DESCRIPTION OF REQUEST: Final Sign-Off For EPC Approved SDP for Amended Site Development Plan For Subdivision

April 17, 2017

**RE: 16EPC-40075 AMENDED SITE
DEVELOPMENT PLAN FOR SUBDIVISION
RESPONSE TO CONDITIONS OF APPROVAL
FOR LOTS 1A AND 2A1, BLOCK 2 SUNPORT PARK
ZONED IP TO SU-1 FOR IP PERMISSIVE USES AND
MULTI-FAMILY RESIDENTIAL DEVELOPMENT
ZONE ATLAS PAGE M-15**

AMENDED SUNPORT PARK SITE DEVELOPMENT PLAN FOR SUBDIVISION

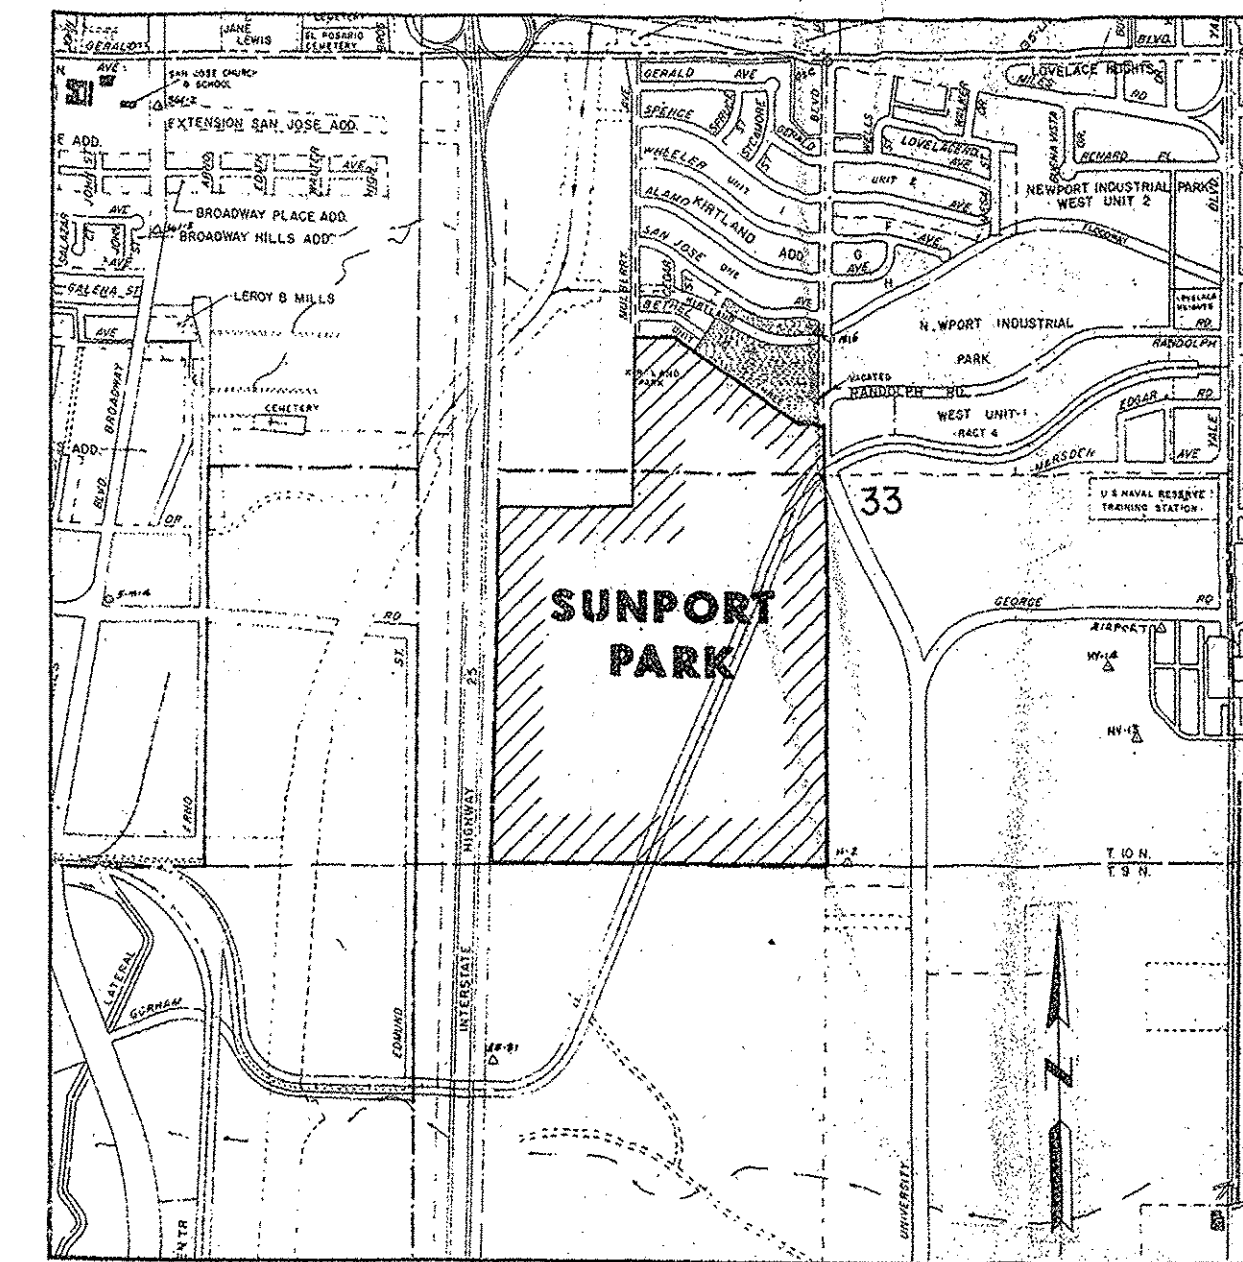
3. The proposed note being added shall be updated to match the proposed zoning descriptor with more exact wording.

RESPONSE: We revised the added note regarding allowable land uses to "allow multi-family residential development" so it more closely matches the proposed zoning descriptor.
